## KITTITAS COUNTY COMMUNITY DEVELOPMENT SERVICES

### RE: Sunny Sage Short Plat, SP-10-00006

The Kittitas County Community Development Services Department has determined that the Sunny Sage Short Plat (SP-10-00006) is a complete application and hereby grants *conditional preliminary approval* subject to the following conditions:

SUNNY SAGE SHORT PLAT

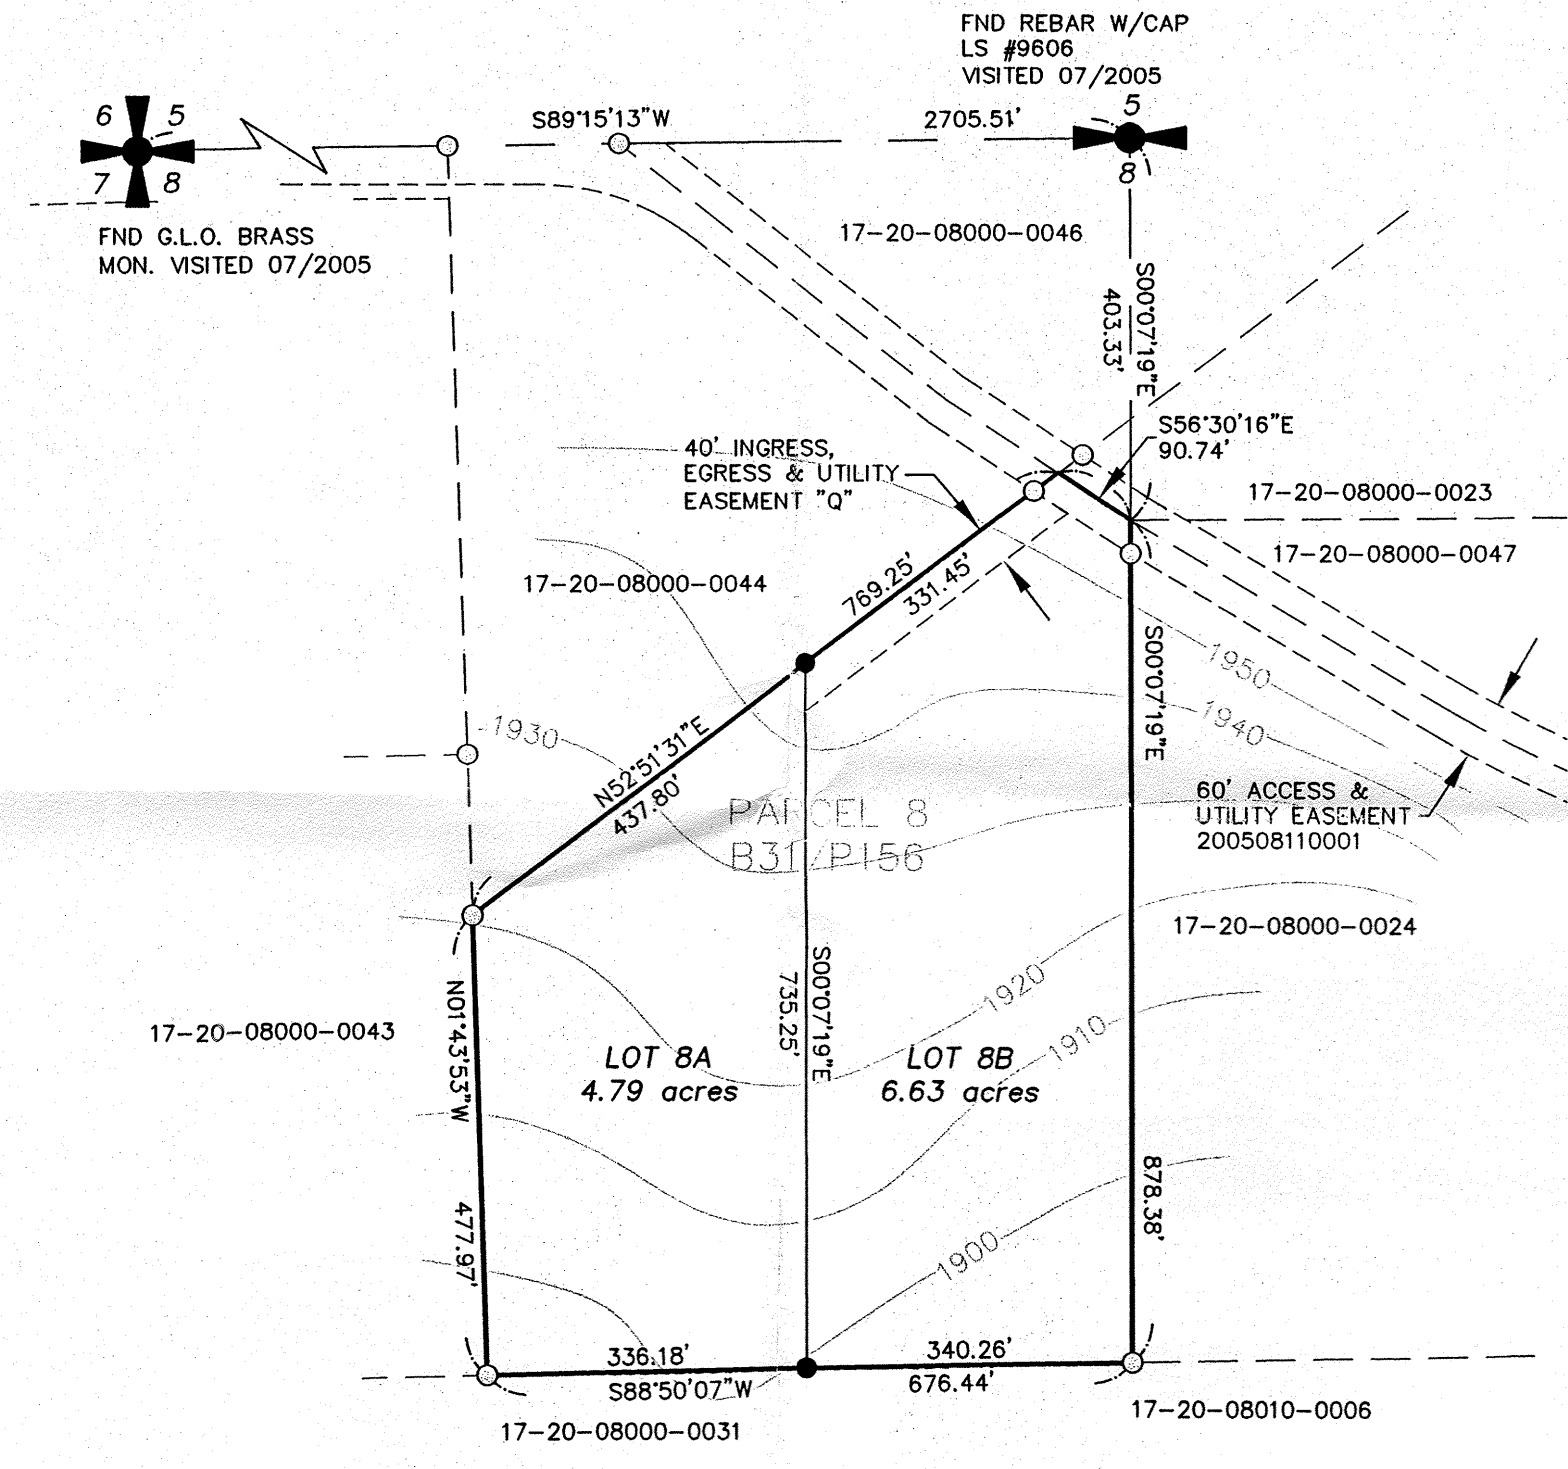
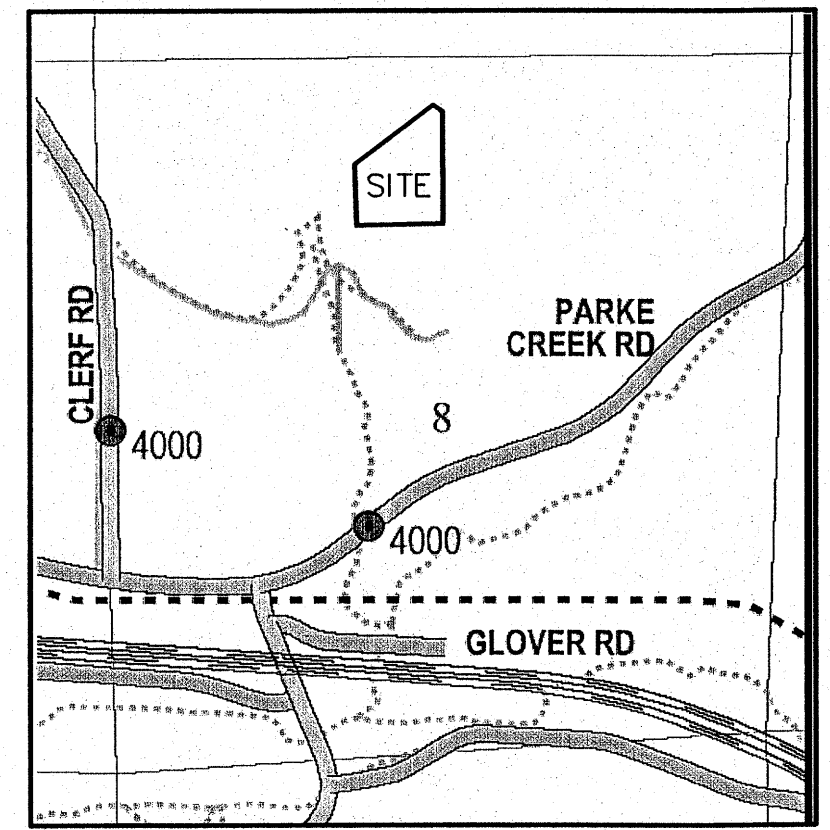
1. Both sheets of the final mylars shall reflect short plat number SP-10-00006 and an accurate legal description shall be shown on the face of the final plat.
